CONSULTEE RESPONSE (Arun District Council - Arboriculturist)

Reference: AW/42/26/PL

Proposal: Refurbishment of the existing community facility and a new single storey extension along the length of the existing courtyard space to provide specialist rooms with 16 No. solar panels on roof. This application is in CIL Zone 4 (Zero Rated) as other development.

Location: Rowland Rank Centre, Aldwick Road, Aldwick, PO21 3QQ

DRAWING
SITE BLOCK PLAN

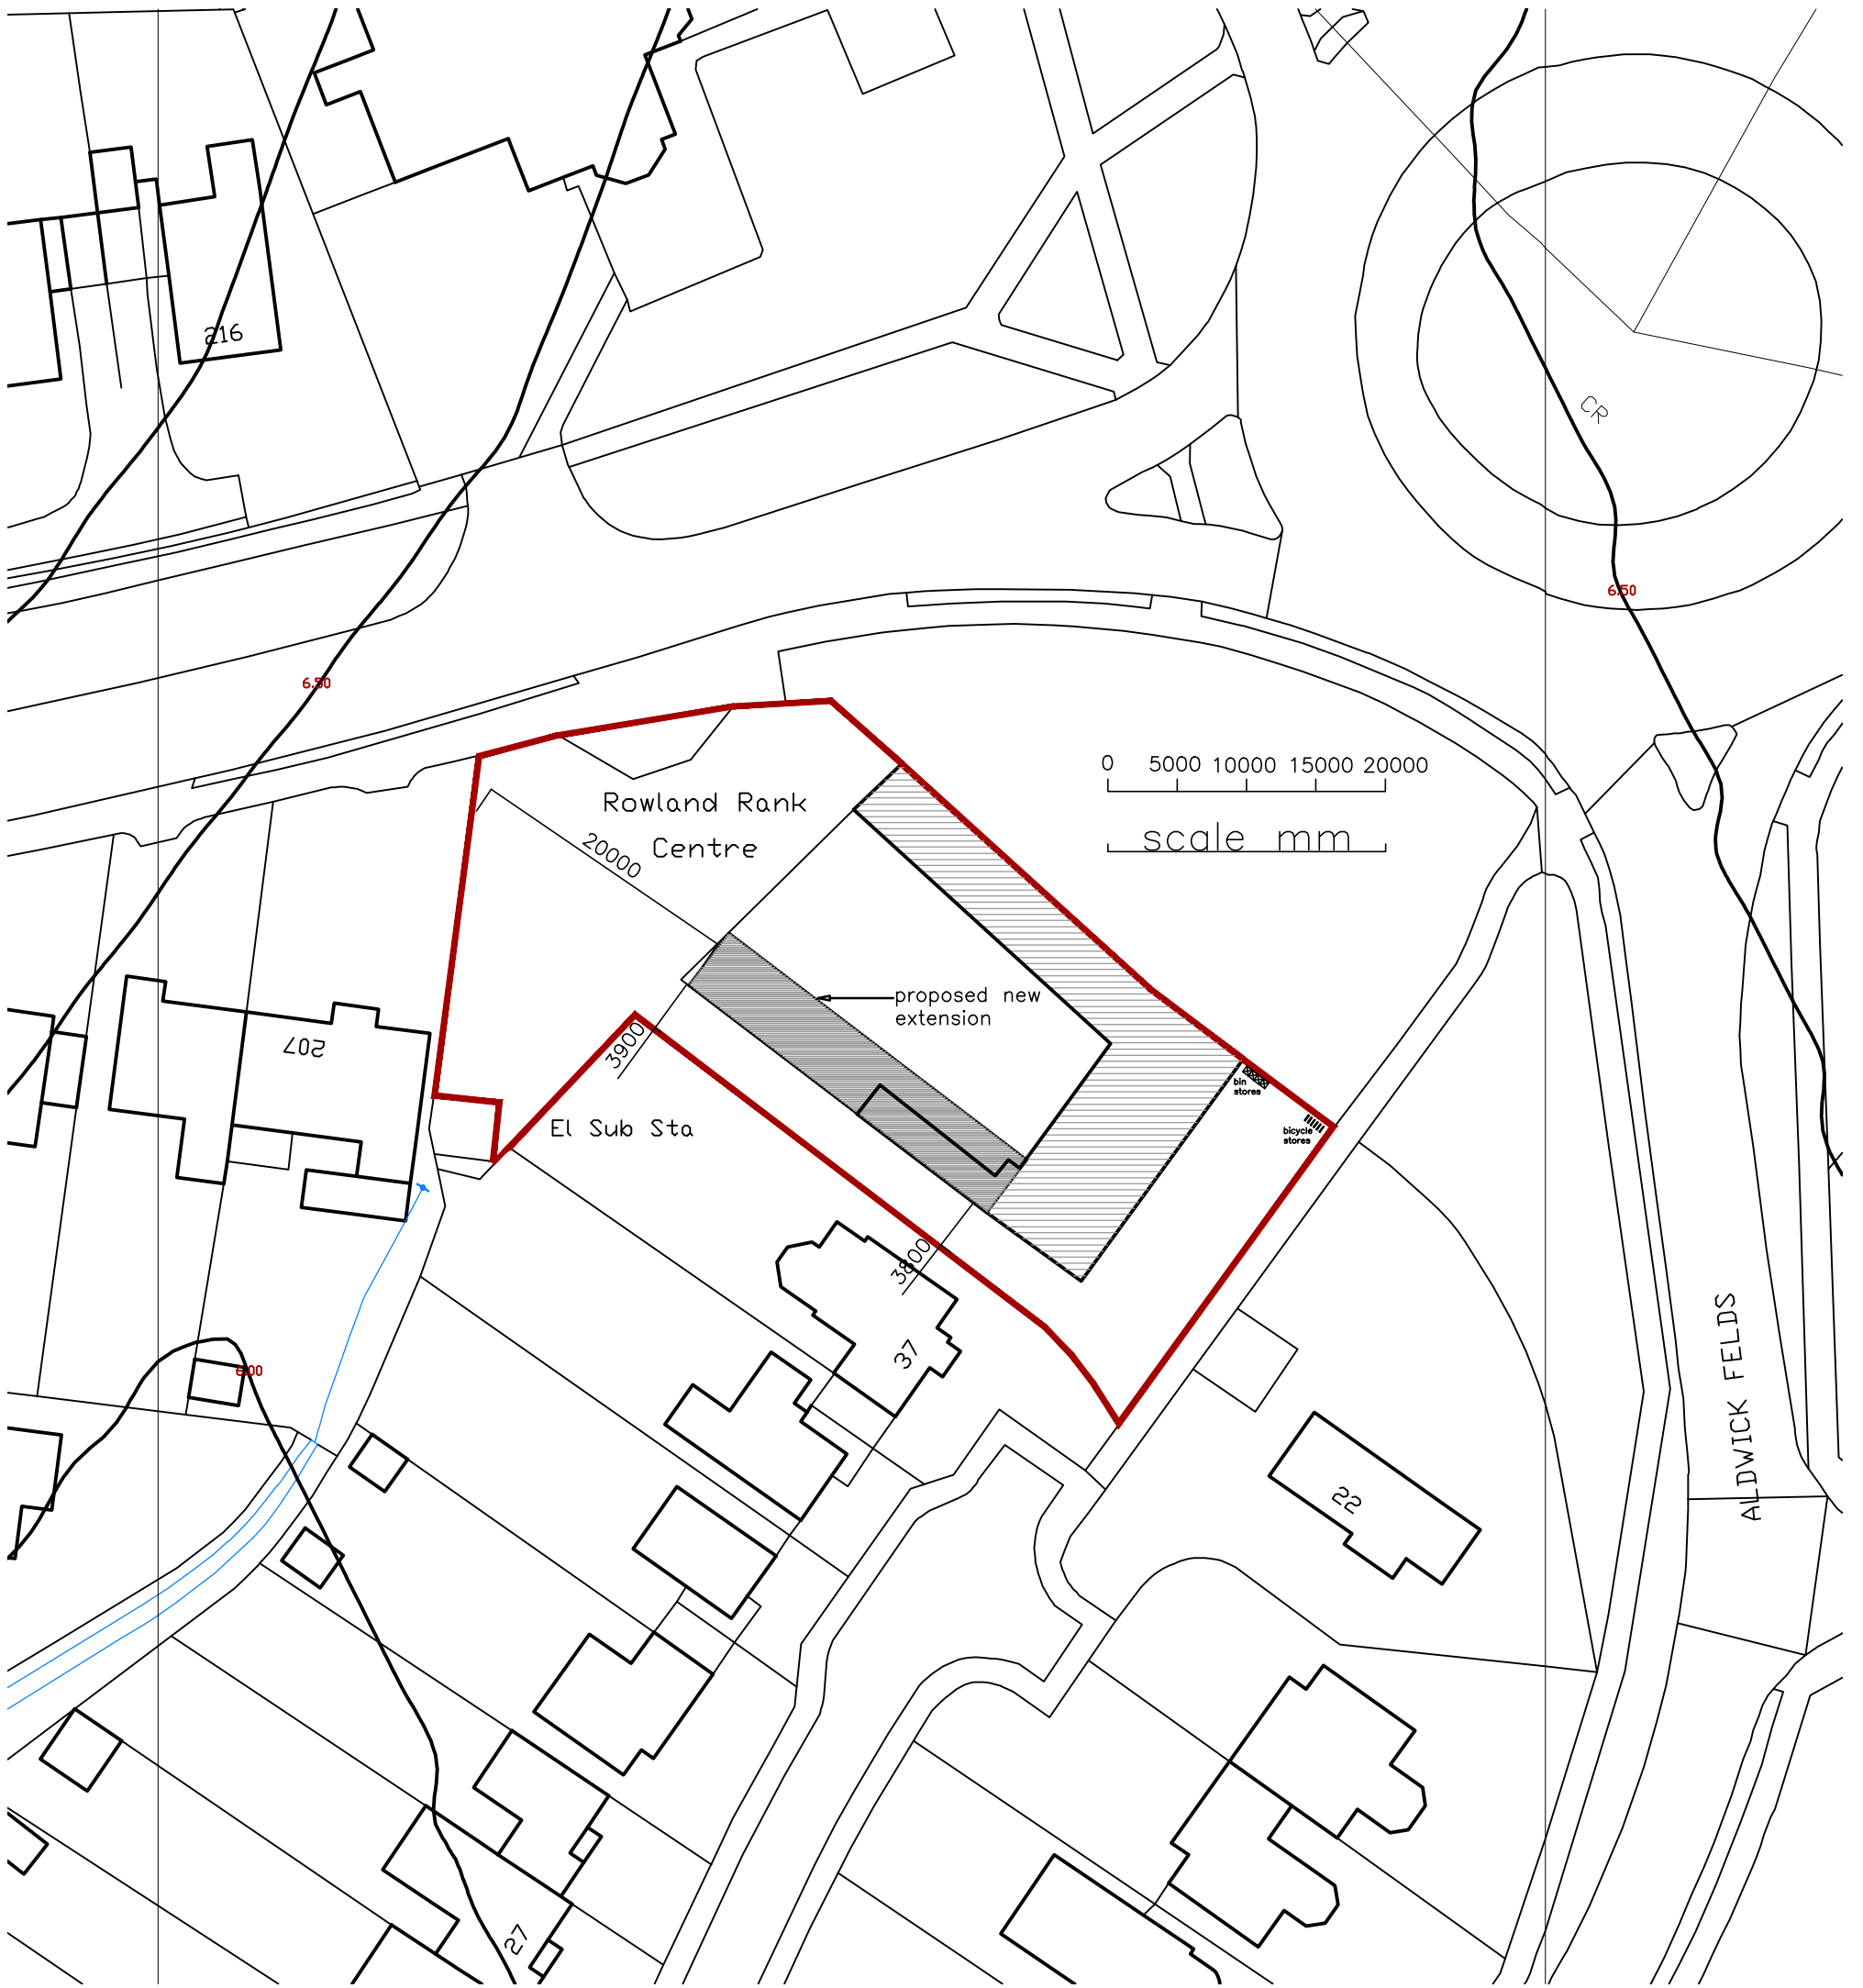
The scheme involves the removal of a prominent tree (their ref. T2), subject of preservation order – TPO/AW/25/10. Justification provided; limited life expectancy and developing conflict with adjacent flint wall. The applicant's arboricultural consultant has noted the potential for tree retention in harmony with the development, although it would require an engineered foundation within the likely rooting zone.

There is limited scope for replanting with a tree of stature, given much of the property frontage is dedicated parking for users of the facility and likely to remain so out of necessity, particularly as capacity would increase. A new hedgerow of mixed native species along the west boundary, to replace H1, is a welcome enhancement although provides little amenity and cannot be preserved by a TPO.

The existing hard surface provides adequate ground protection for the construction phase and the AMS provides additional guidance should any excavation/enhancement be desired post-development.

A purpose-built tree pit within the existing hard surface frontage, to accommodate one selected standard of the types proposed in the tree report, would be problematic and invite considerable nuisance at near-maturity, if indeed it was able to tolerate such harsh surroundings (non-porous hard surface).

I see no reason to object to this proposal on arboricultural grounds. If approving the application, please include the following condition:

All activity at the site is to be carried out in strict accordance with: - Tree Survey & Report, Beechdown Tree Consultancy, ref. B/0645/26, 23rd March 2026

If there is deemed to be a need for any Utility Service Route connections to bisect retained tree Root Protection Areas/Zones, then prior to their installation a Method Statement prepared by an Arboricultural Expert must be submitted that stipulates how this can be achieved without adverse impact on tree roots. Written approval and confirmation of acceptance of this Methodology must be issued before any works are commenced out on site.
